**From:** Martyn White  
**Sent:** 11 December 2018 17:20  
**To:** Planning.Responses  
**Cc:** Anita Gardner  
**Subject:** LU/328/18/PL

**LU/328/18/PL**

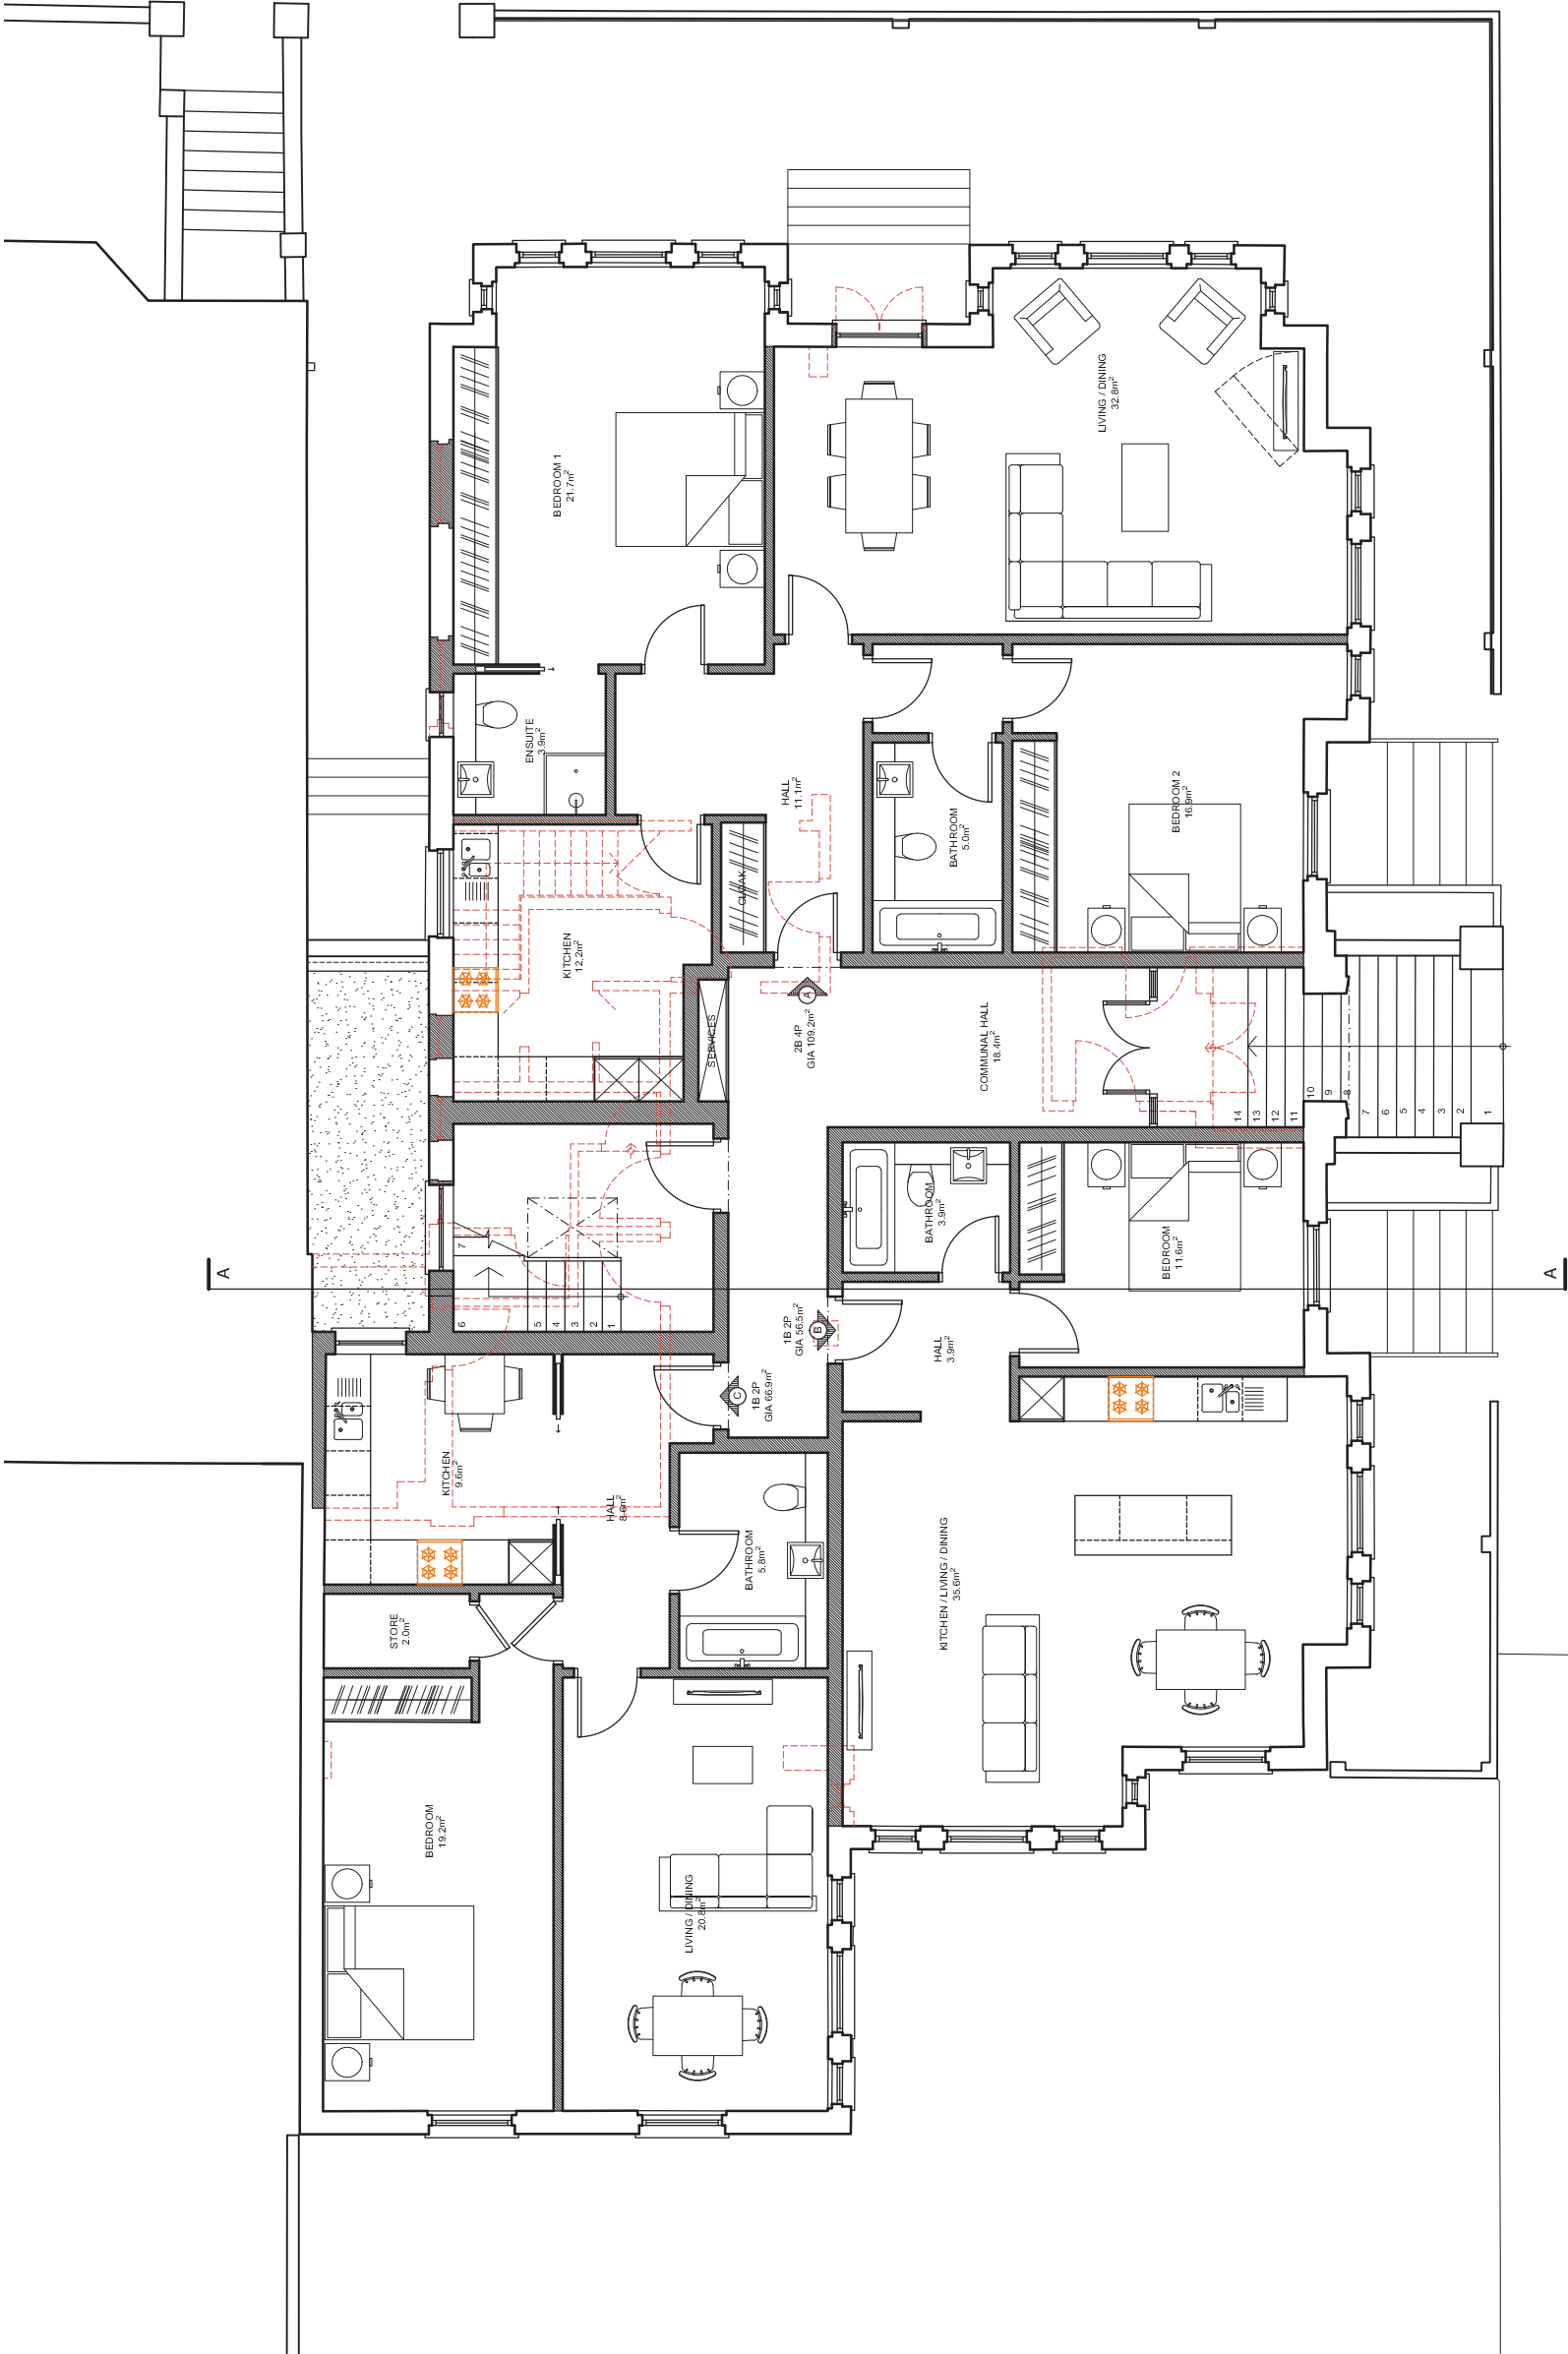
I note that reference is made to the removal of the upper ground floor south facing balcony and French windows within the Design and Access Statement. However, they still appear on the plans and it is not clear which approach is correct. I am of the opinion that the balcony and French windows should remain as part of the scheme, and would enhance the elevation.
